Technical Memorandum

29 August 2023

To	Angus Walker	Contact No.	-
Copy to	Andrew Byrne	Email	-
From	Matthew East	Project No.	12578580
Project Name	DFDS Traffic Impact Study - Immingham		
Subject	IERRT – DFDS Written Response Addendum – Annual Throughput and Terminal Capacity

For Continuation See Sheet 2

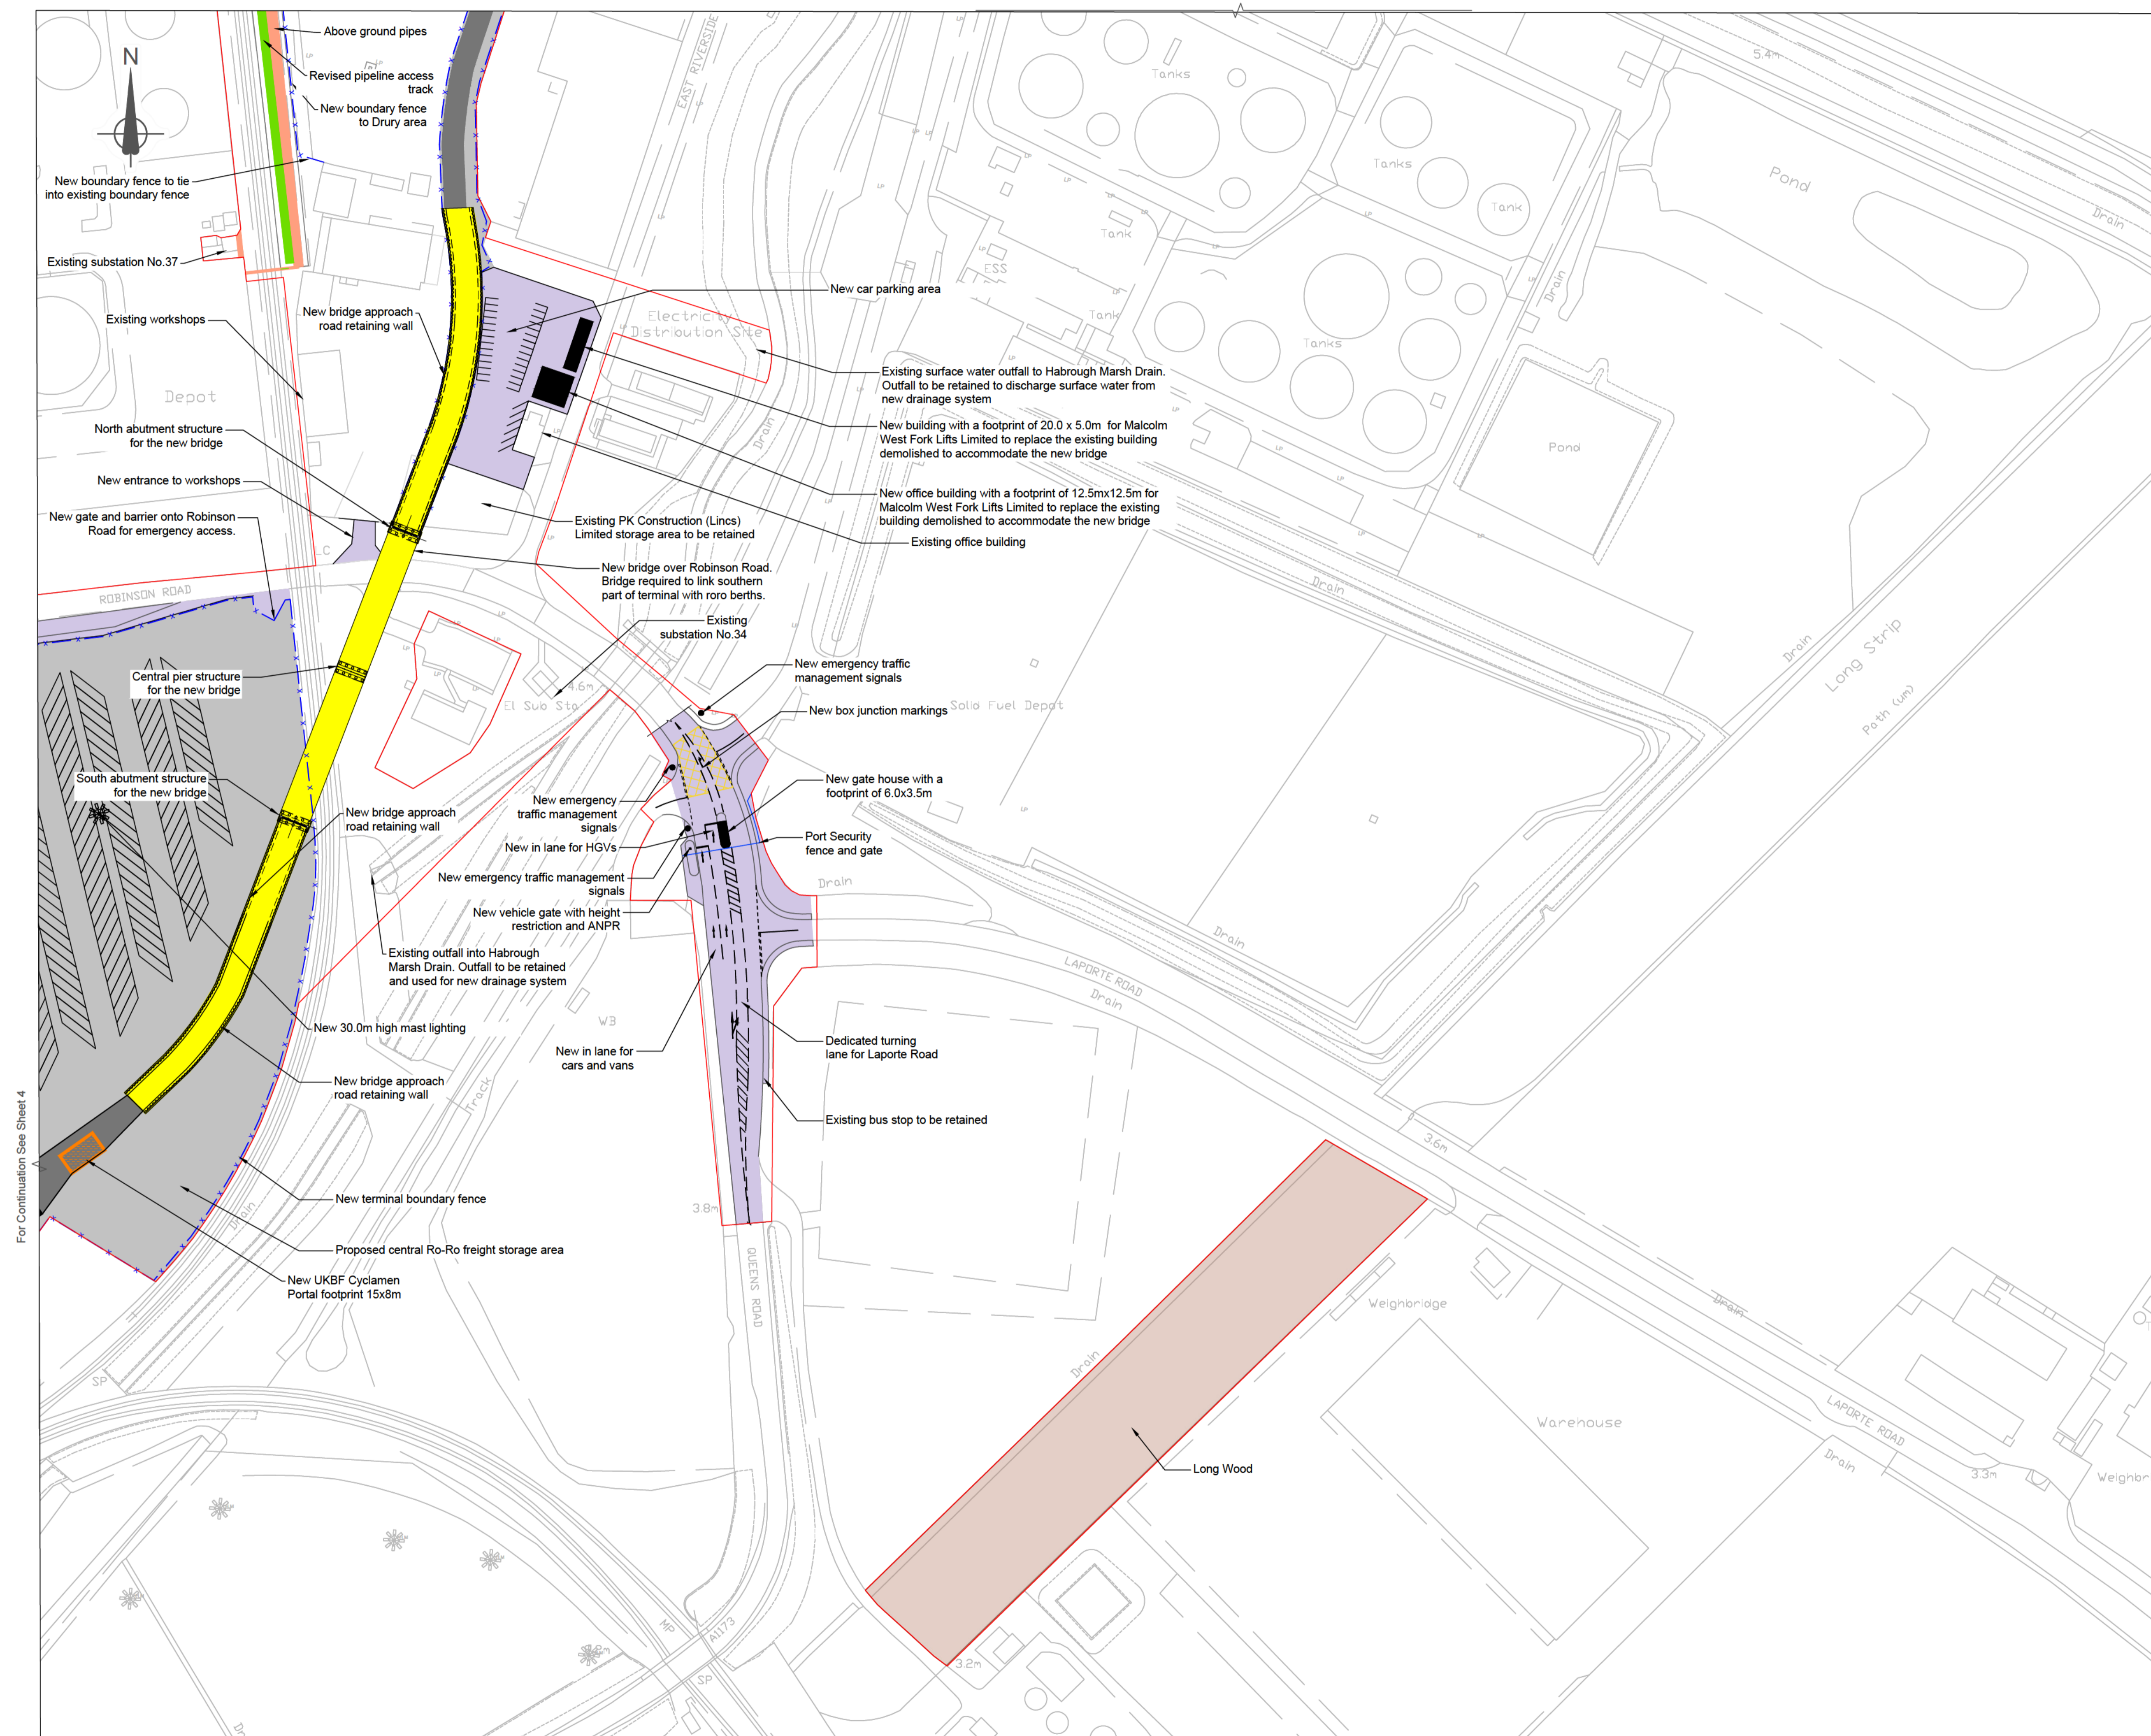
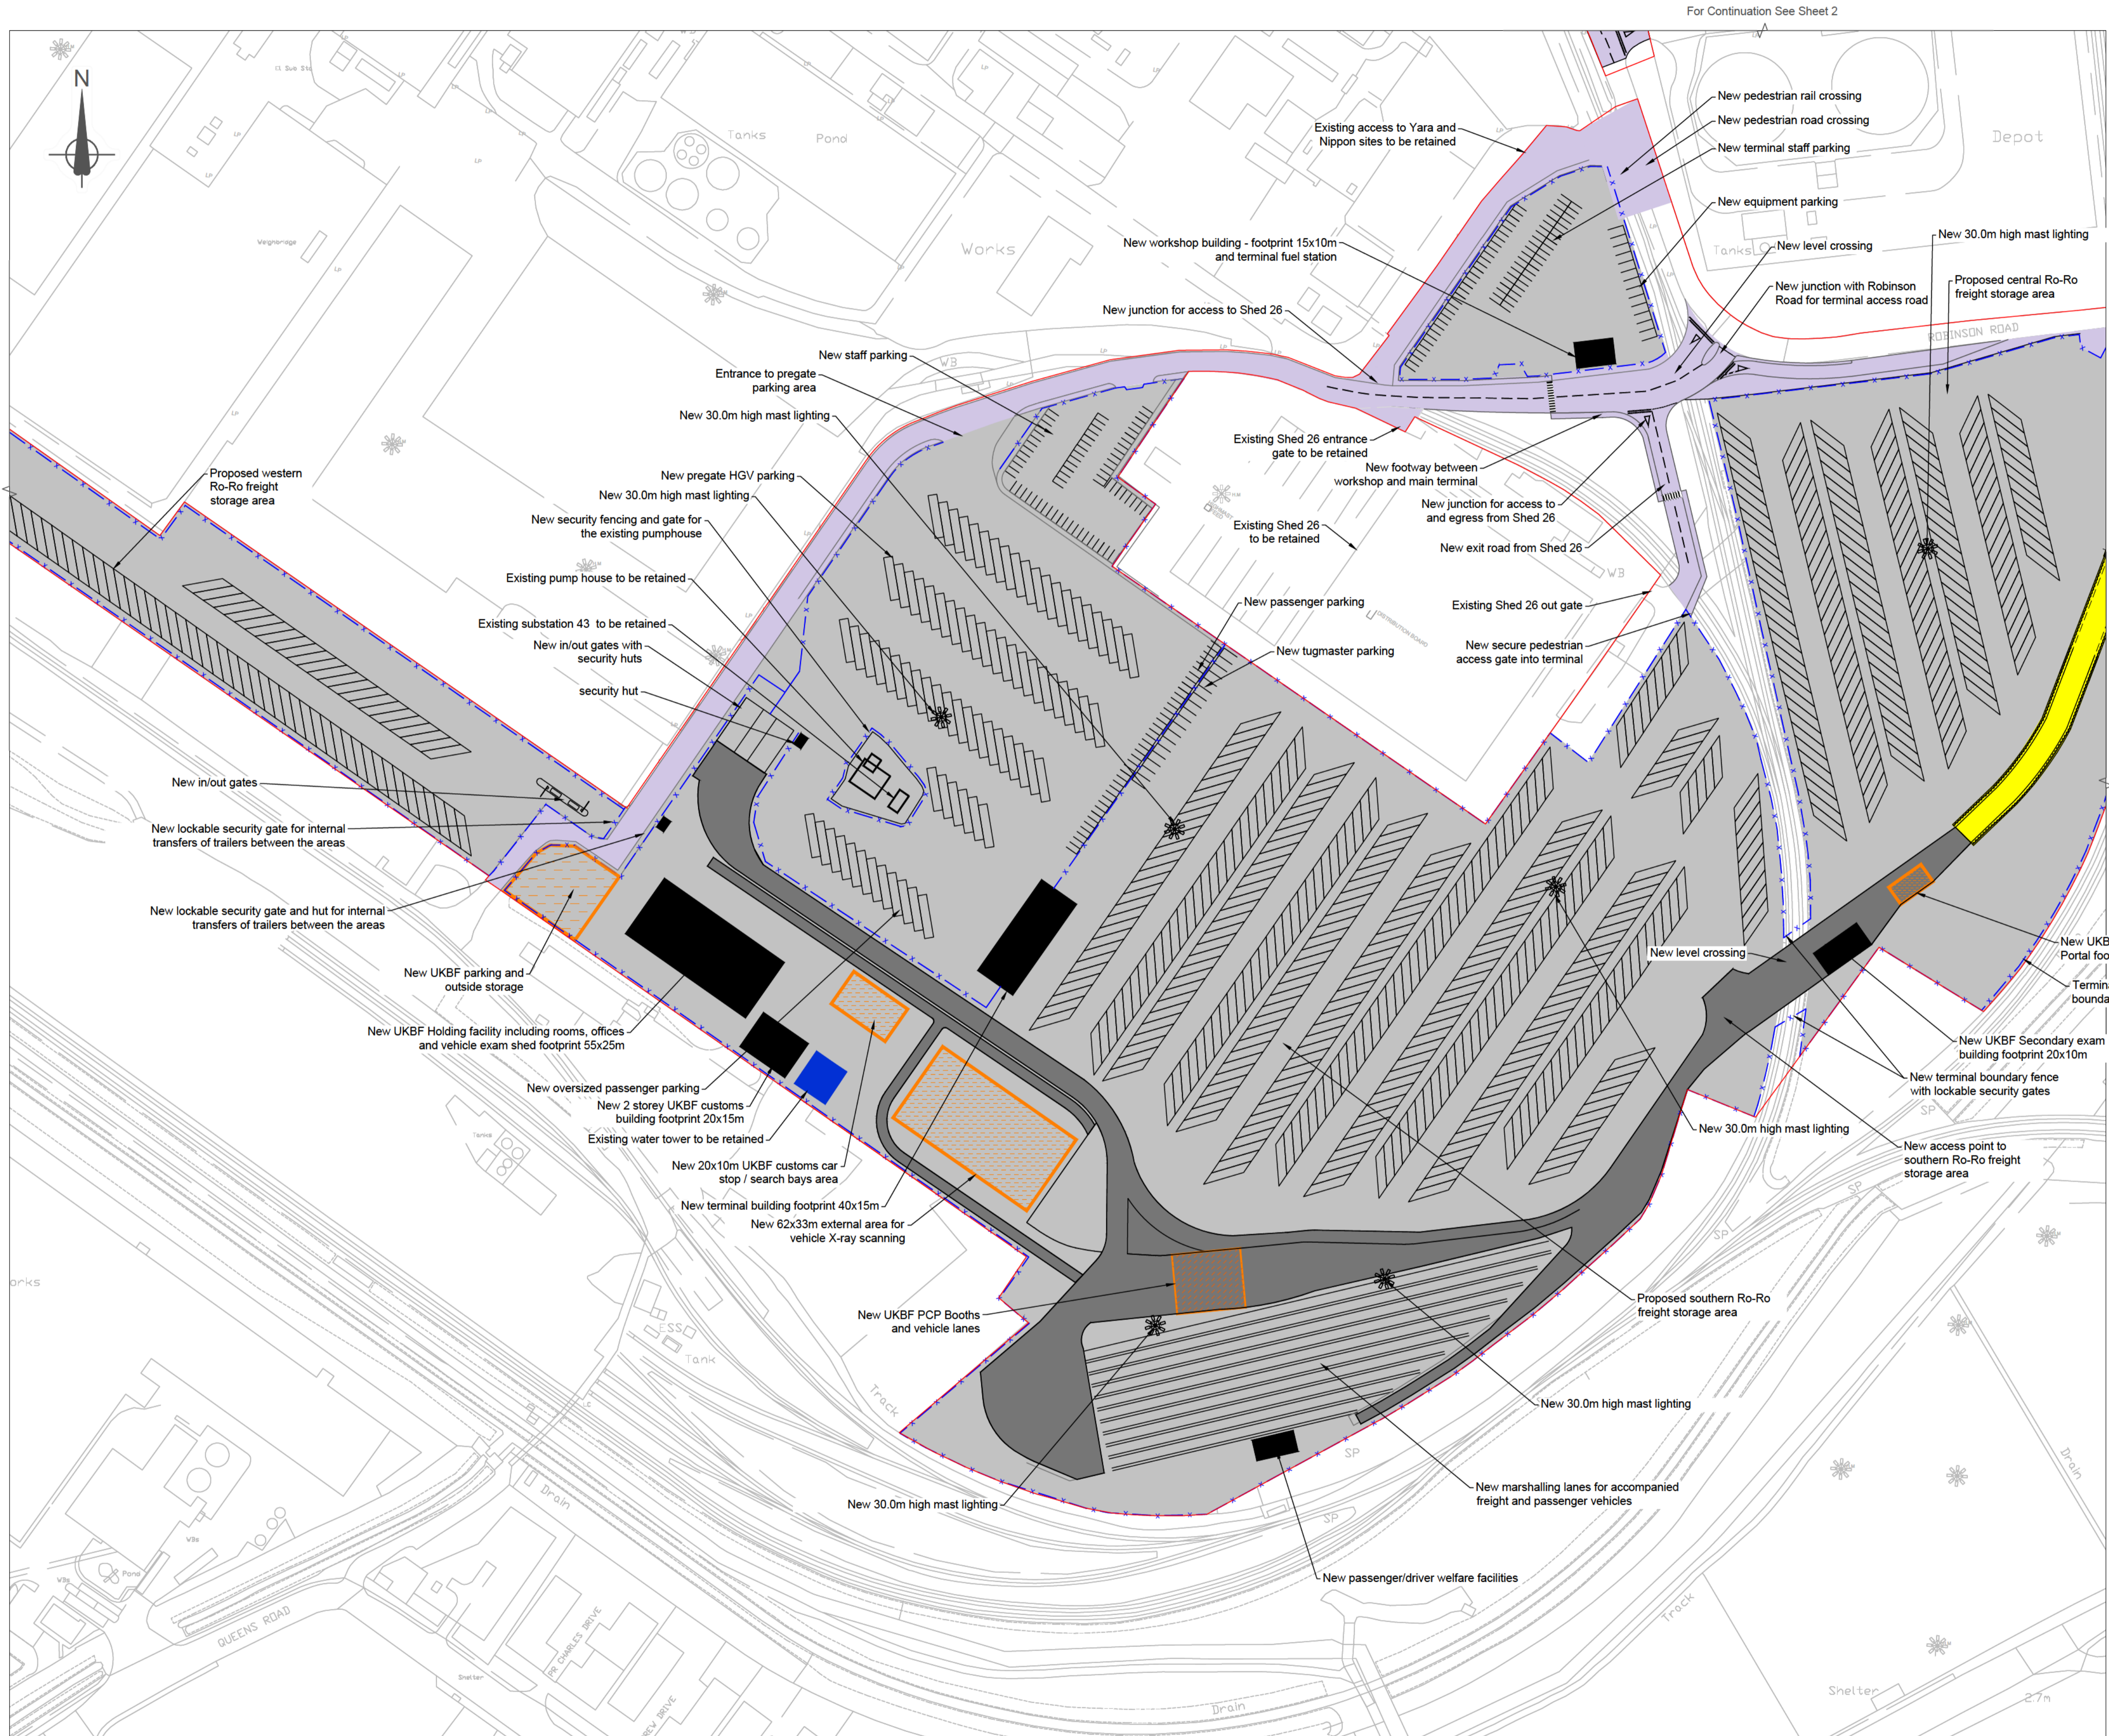
The intended configuration of the IERRT terminal is described within the Engineering Sections Drawings and Plans¹¹. These drawings identify:

- The location, stack height and number of slots for containers (slots are described in twenty foot equivalent units (TEU));
- The number of bays for trailer parking;
- Swimlanes for accompanied unit parking prior to boarding vessels; and
- Waiting areas external to the terminals security gates which are within the terminals boundary.

GHD have reviewed these drawings and identified the following approximate figures (note, as the files are only provided in pdf format, counting and measuring has had to be completed manually potentially leading to minor discrepancies in values presented).

Area	Lane Meters (m)	Container Slots (TEU)	Trailer Spaces (Units)
Northern	0	38	239
Central	0	0	157
Southern	1,420	0	355
Western	0	0	635
Total	1,420	38	1,386

Assuming a provision of 18 metres for each accompanied unit, and a stack height of three (3) containers per slot (as shown in the Engineering Drawings), the current terminal provides static capacity for:

- 79 spaces for waiting export accompanied units within the terminal, and a further 78 waiting spaces outside of the terminals gates (it is assumed imported accompanied units will not reside at the terminal, therefore spaces would only be utilised for exports);
- 114 TEU's (containers) for imports and exports; and
- 1,386 spaces for unaccompanied trailers for imports and exports.

Using the identified terminal configuration and operating assumptions, and assuming that on a peak day that all spaces are utilised within the terminal, the terminal configuration only has sufficient capacity if the dwell rate of unaccompanied and containerised is an average of around 2 days.

However, under the circumstance that all unaccompanied and containerised spaces are utilised, there is likely to be operational challenges generating congestion at the terminal gatehouse, which will in turn create delays for vehicles entering the terminal, leading to queuing back onto the port road network.

Further, for the terminal to handle 252 accompanied units to be loaded onto the departing vessel, the swimlanes provided to would need to be replenished in excess of 3 times (i.e. once per vessel). This would mean that the applicant would need to ensure that boarding of the vessels is completed against a controlled schedule. This is also operationally complex and has a high potential of resulting in congestion and queuing on the port road network.

Based on operational parameters identified and carrying over the average dwell rate of 2.1 whilst factoring in the estimated peaking factor based on DFDS operations of 122%, the terminal is estimated to have an annual capacity of just under 300,000 RoRo units per year¹⁸. In a simplified view, this is determined by the following equation:

This is substantially less than the quoted maximum of 660,000 units per year. This supports the applicants consultant view that the terminal acts as a physical control on the annual throughput and the maximum volume in the dDCO would not be achievable.
